Public Submissions Response

State Significant Development SSD-17424905
Pymble Ladies College – Grey House Precinct
20 Avon Road, Pymble (Lot 1 DP 69541)

SHADOW DIAGRAMS -
SHEET 1

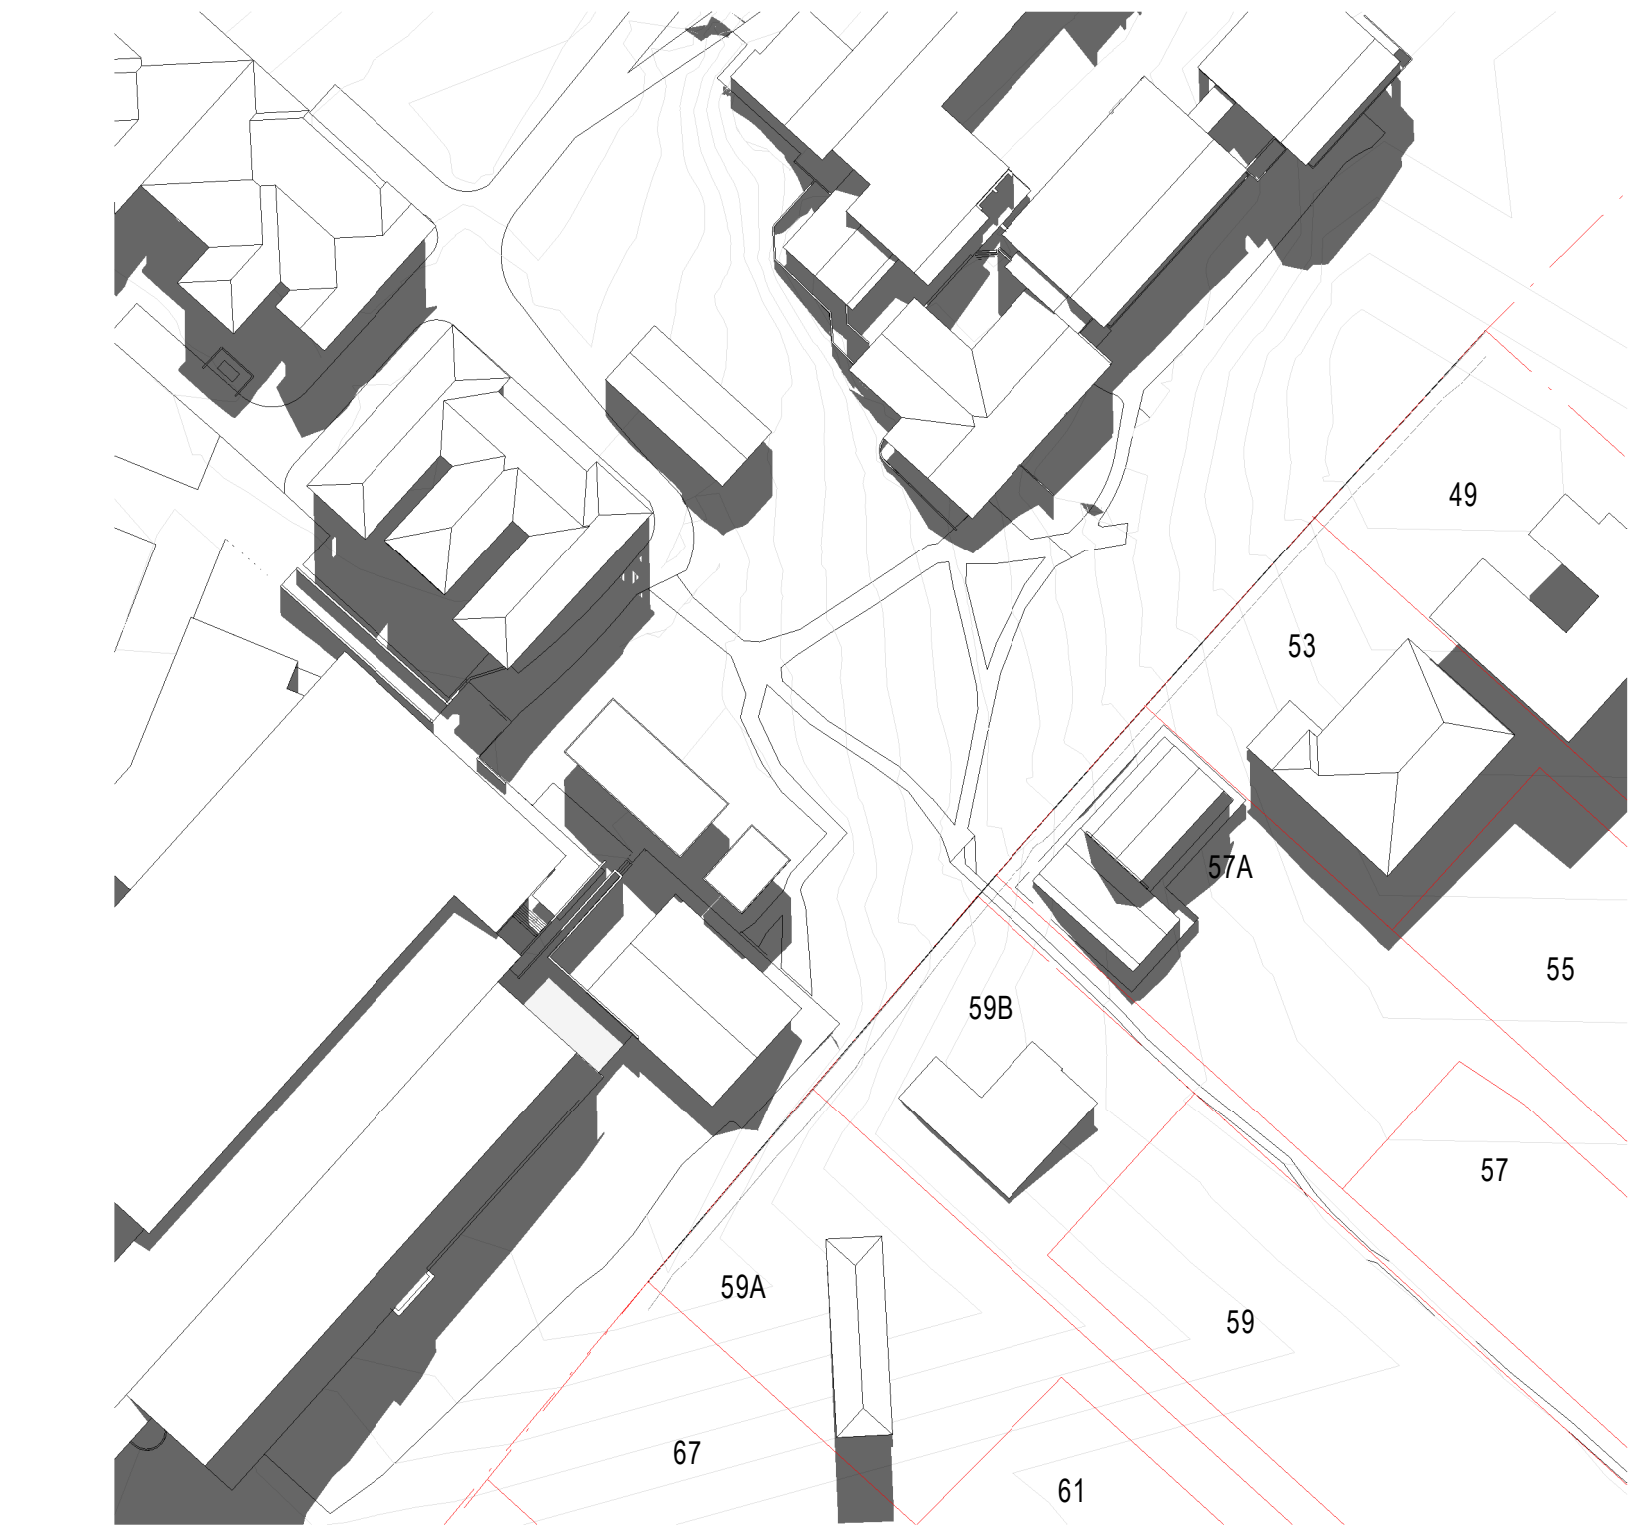
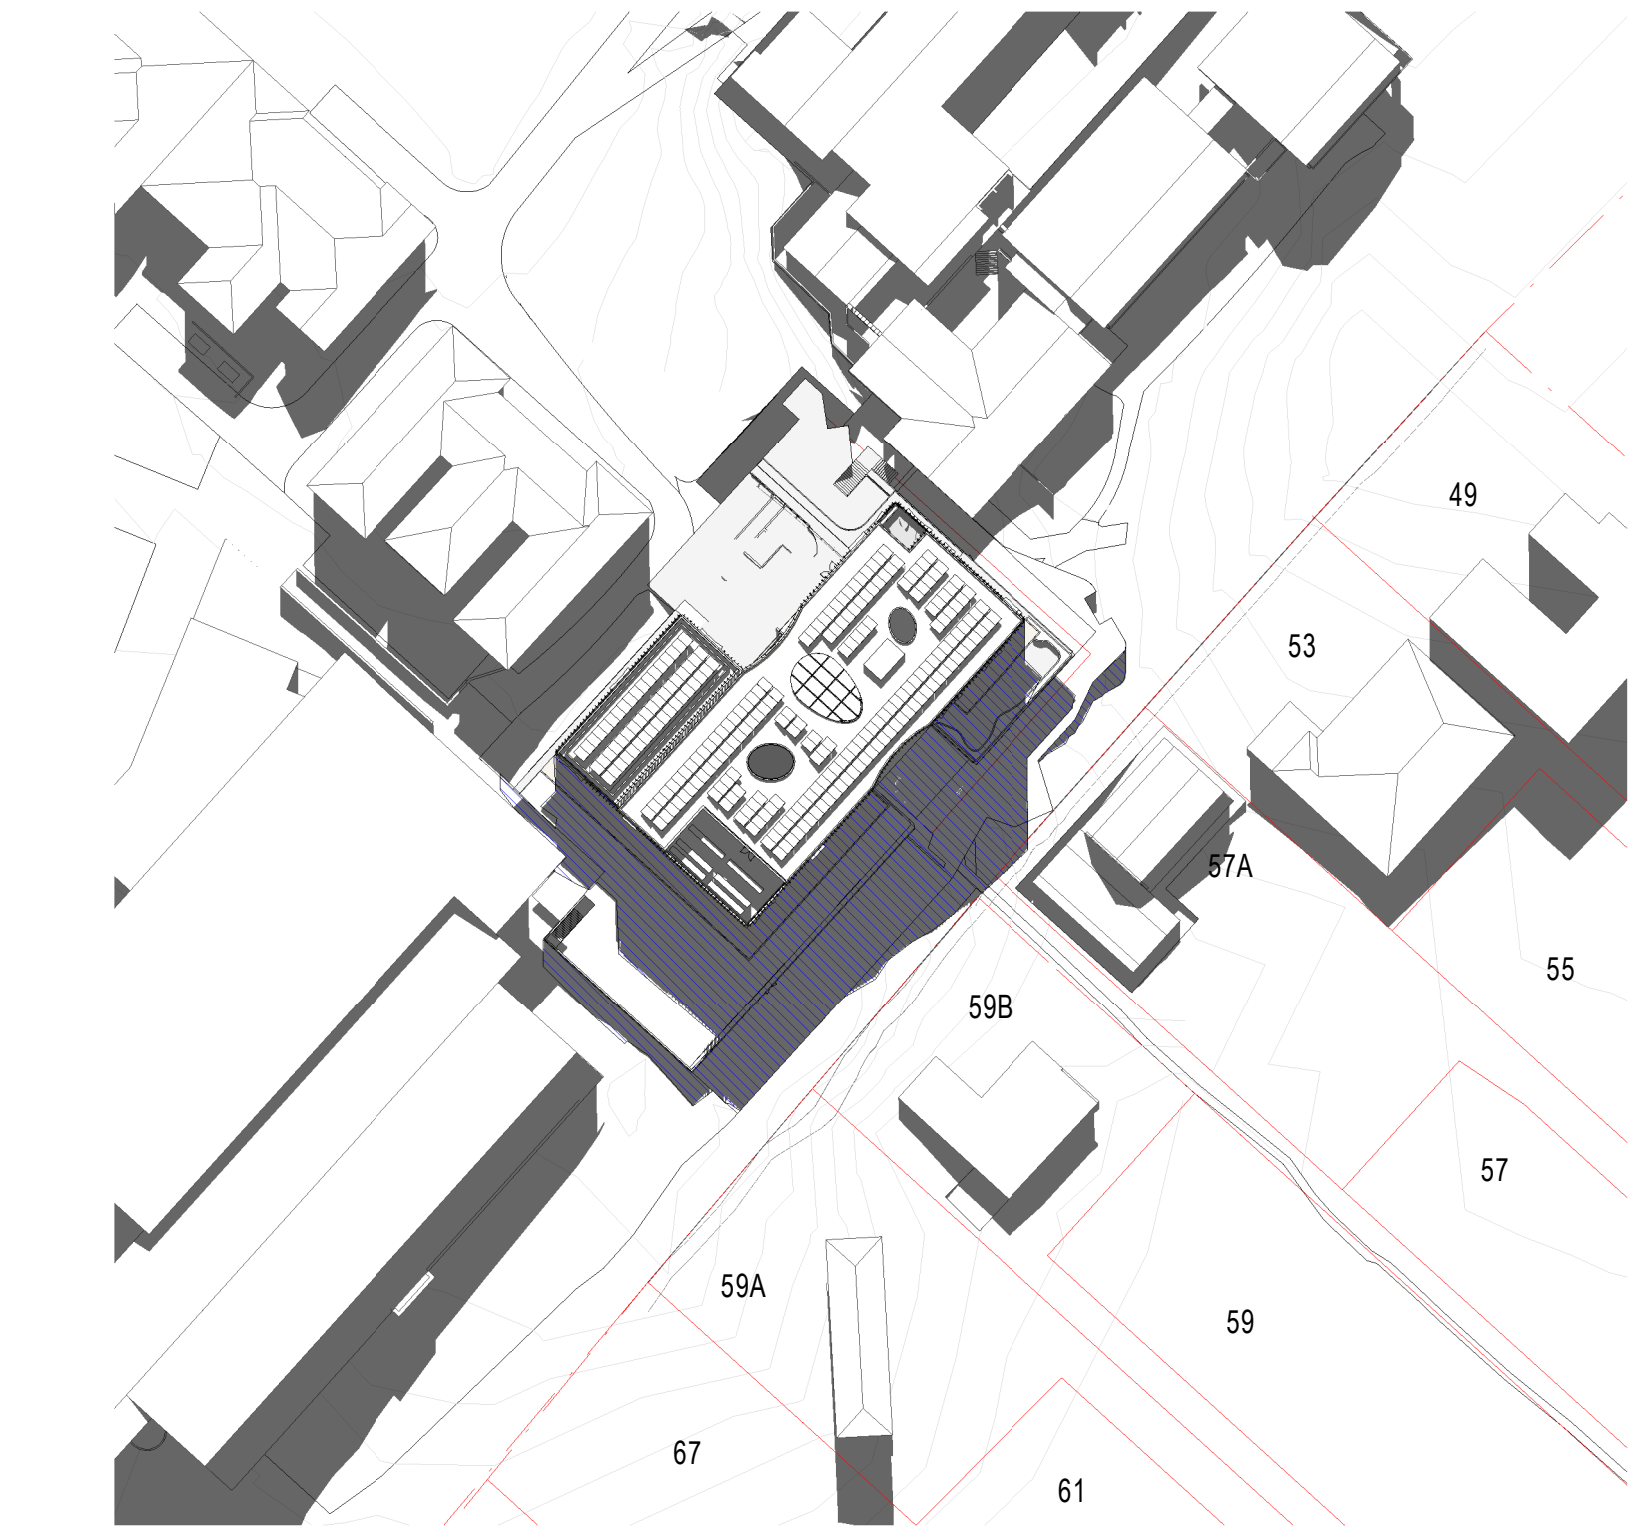
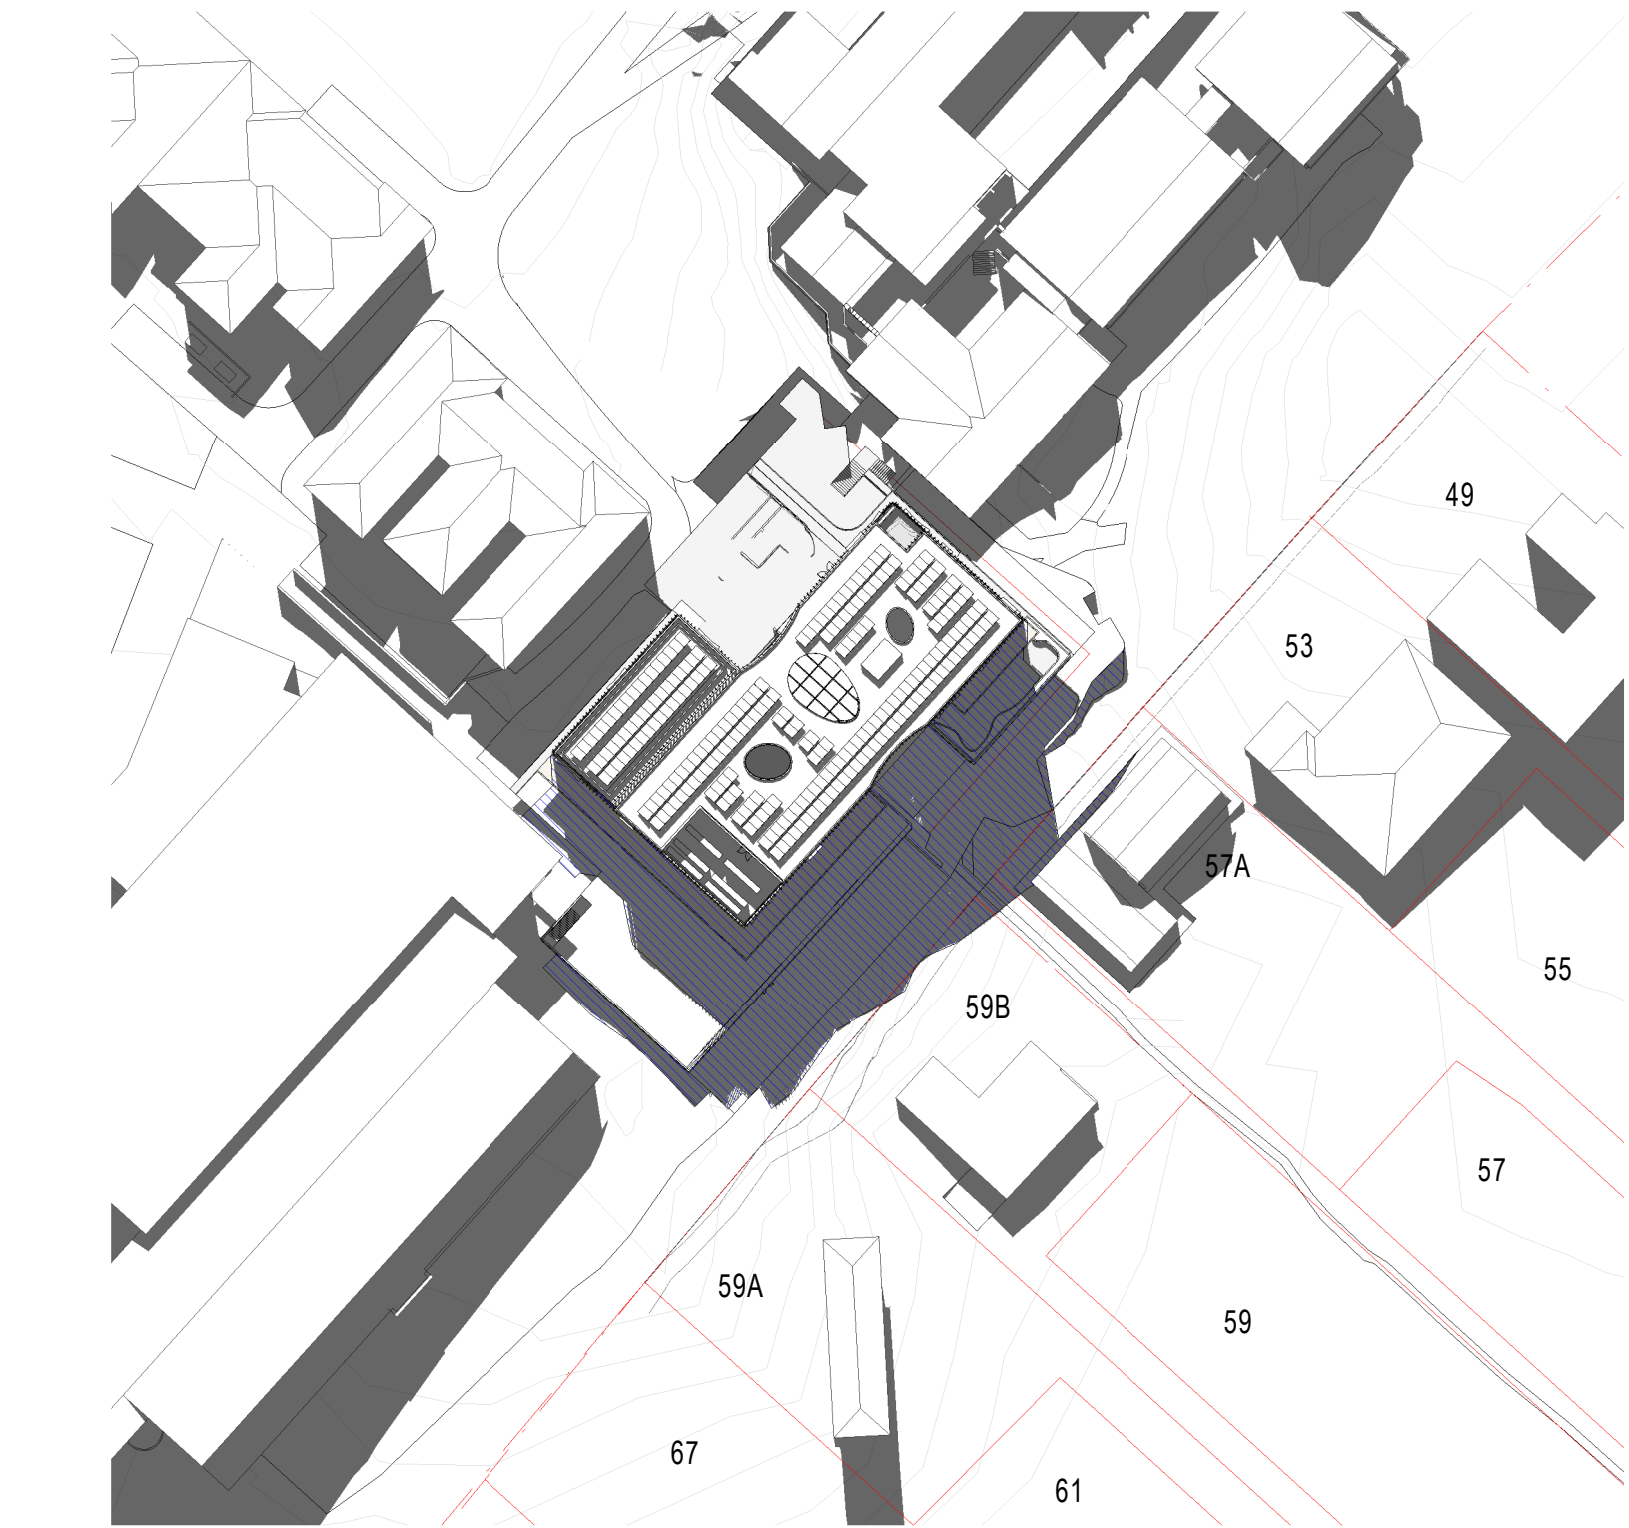
<p>Building Height</p> <ul style="list-style-type: none">- The building height is contrasting to the surrounding 1-2 storey buildings- The upper floors of the building create bulk, overshadowing and privacy issues- The proposal is contrary to the KLEP2015 objectives in relation to establishing a transitional scale between centres and adjoining lower density residential spaces to protect local amenity as well as enabling development with a built form that is compatible with the size of the land.	<p>The proposed building has been designed to minimise the perceived scale and height. Given the surrounding topography, the building presents as differing building heights and is further broken up by horizontal and vertical façade articulation and use of different materials.</p> <p>The proposed development has been amended to further reduce the perception of bulk and scale, through increasing the brick podium base, setting back the upper storey of the building, increasing the scalloped entrance detailing and utilising additional different</p>

<p>materials and the additional of horizontal elements to break down the building.</p> <p>Substantial testing has been undertaken on the solar access to the nearby residences, and it is considered that these residents would still receive ample solar access to living and private open spaces. This is consistent with the relevant State and Local guidelines in relation to solar access.</p> <p>The vertical fins, substantial setback and topography limit the ability of overlooking into the neighbouring properties. Detailed sight lines have been provided in Attachment A and B. The upper levels have minimal potential for overlooking, however these are the health rooms and would not have large numbers of students in them. Further substantial landscaping has been provided along this boundary which assists in improving the residential outlook and further limiting impacts on privacy of the residents.</p>
